6th February 2023

Assigned planning officer: Ben Taylor
Ribble Valley Borough Council
Planning, Buildings & Countryside
Council Offices
Church Walk
Clitheroe
Lancashire
BB7 2RA

Objection to Planning Application: 3/2022/1073 – 77 Ribchester Road

1094/RRC/PL1 | **C**

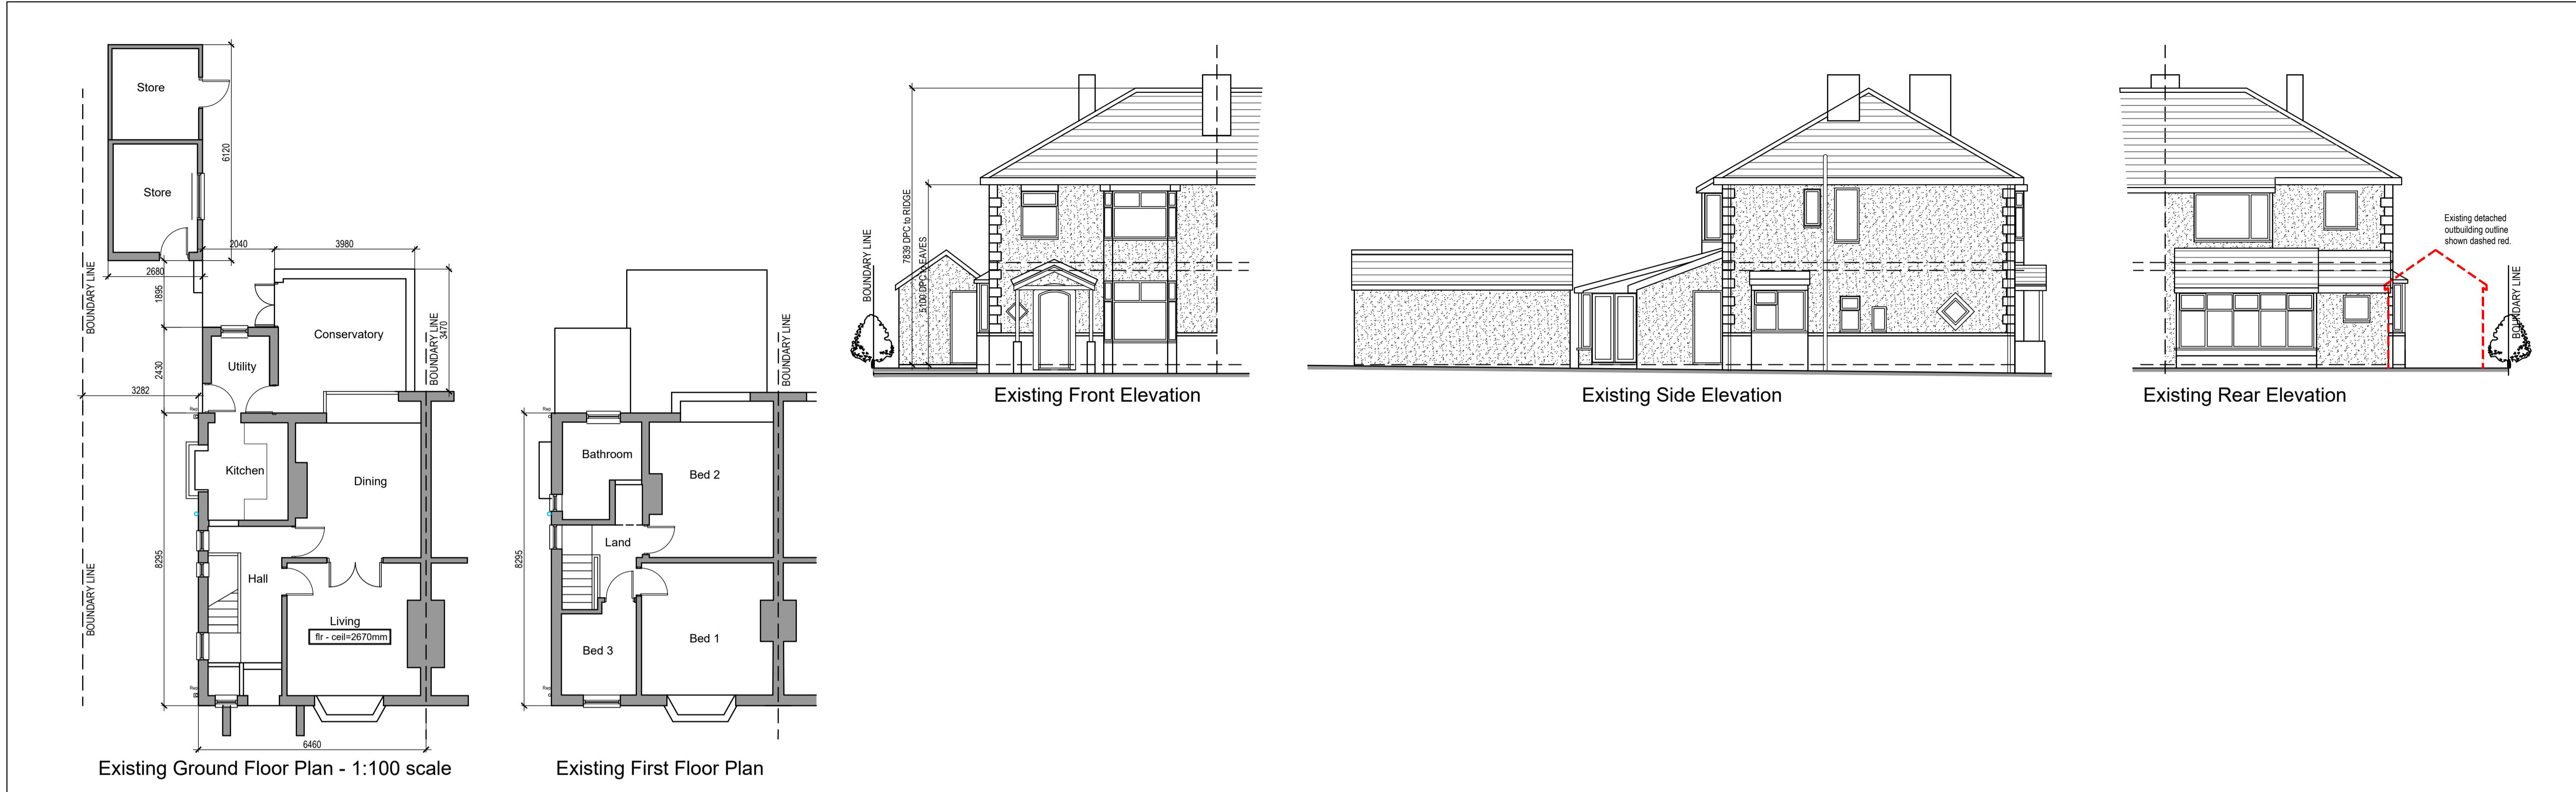
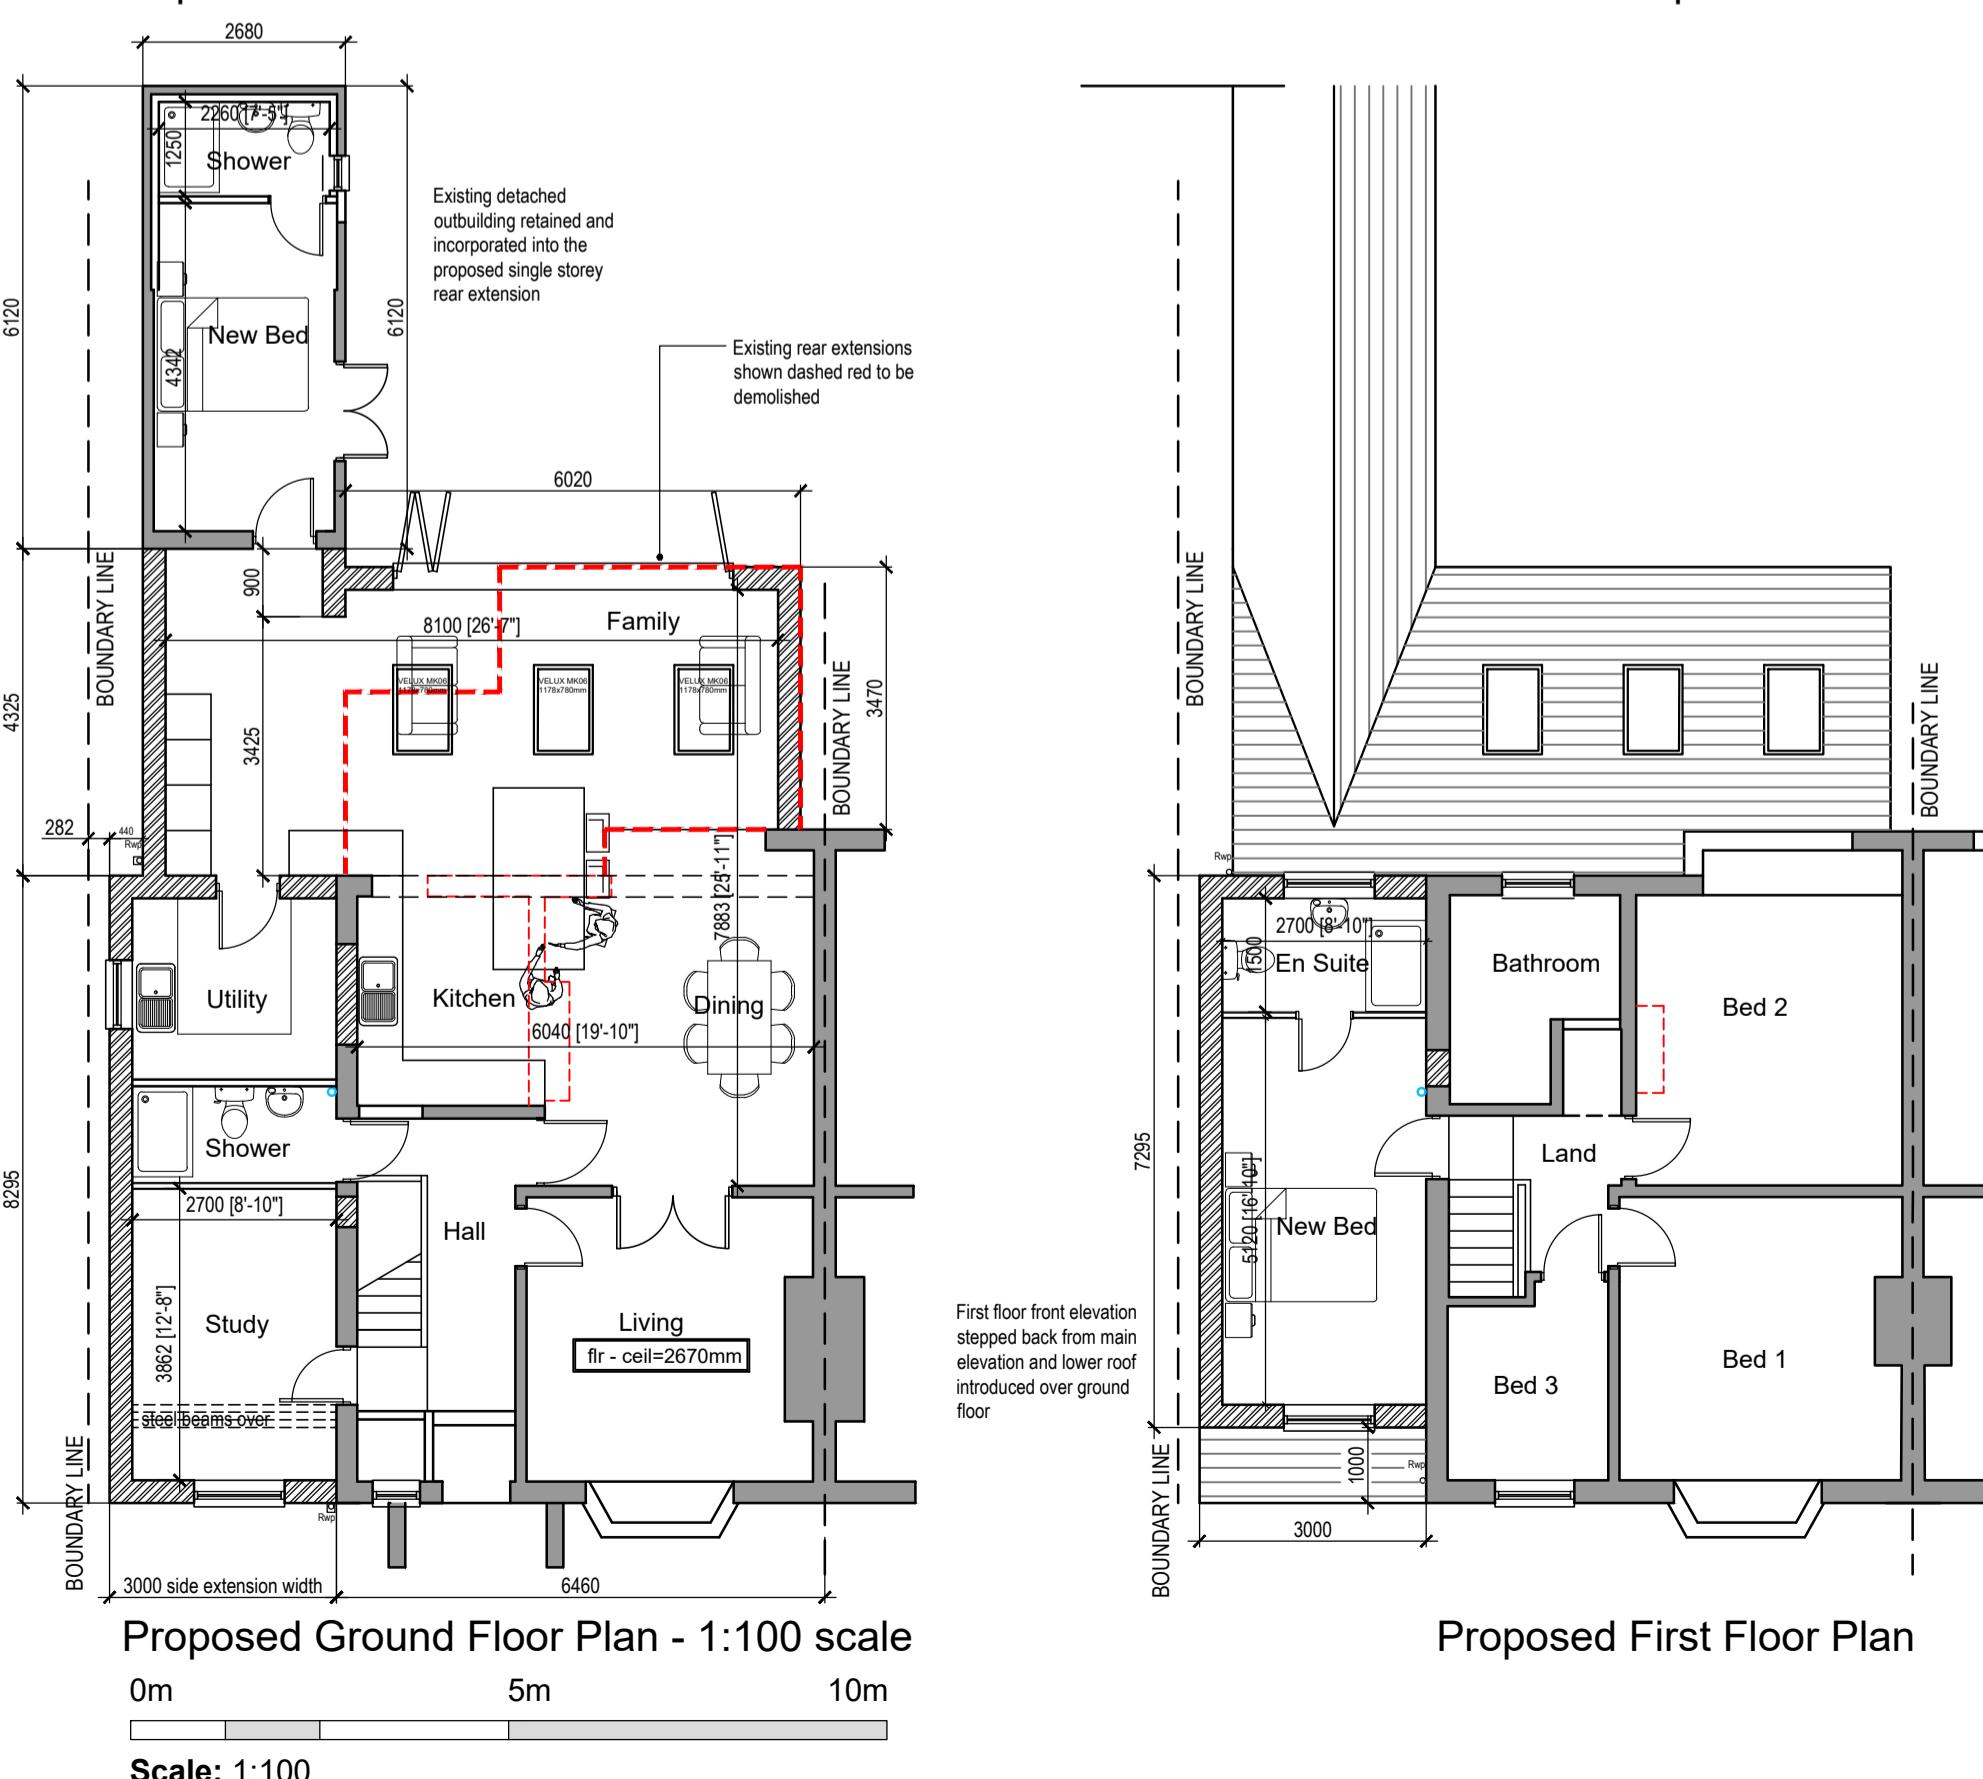
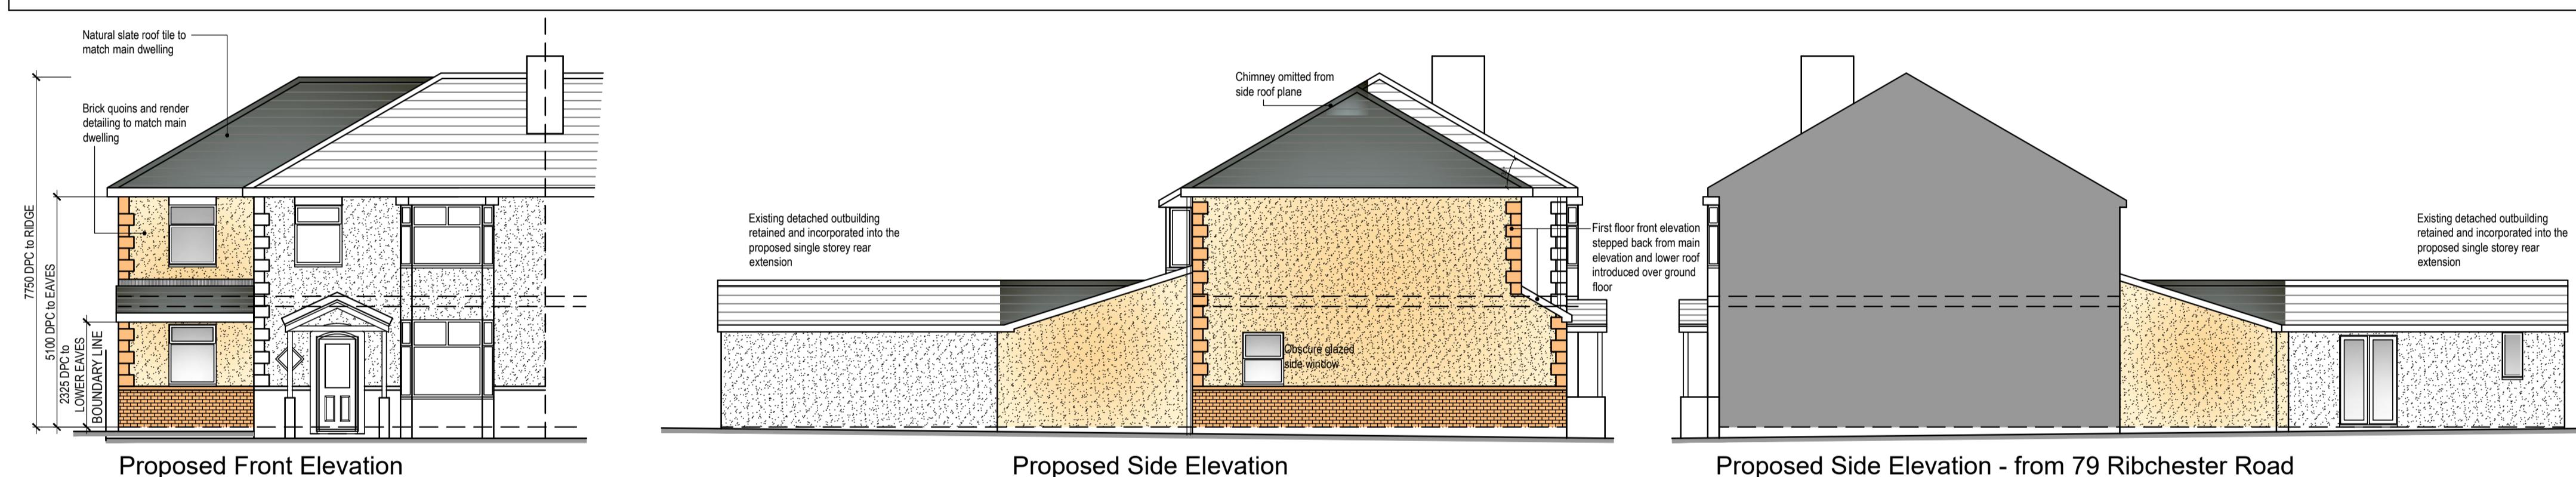
After studying the plans as submitted online, it appears that the proposed two-storey extension would be [REDACTED] would be detrimental to [REDACTED] being overbearing and overshadowing because of size, [REDACTED]

I strongly object to the large and excessively long single storey rear extension, which will negatively impact on the outlook from [REDACTED] and which could also reduce the amount of sunlight and natural light received in [REDACTED]. The excessive length of the extension to the rear will create a very long section of solid wall which will be very unattractive and of poor design quality.

In the event that you do not concur with these objections, at the very minimum, we consider that the scheme should be significantly scaled back with the two-storey side extension set in from the boundary by at least 1 metre. This would appear necessary in any event in order to enable construction. Regarding the single-storey rear extension, this should be set in by a further 1 metre from the boundary and reduced in overall length to avoid an excessively long length of blank wall, which is both overbearing and unattractive.
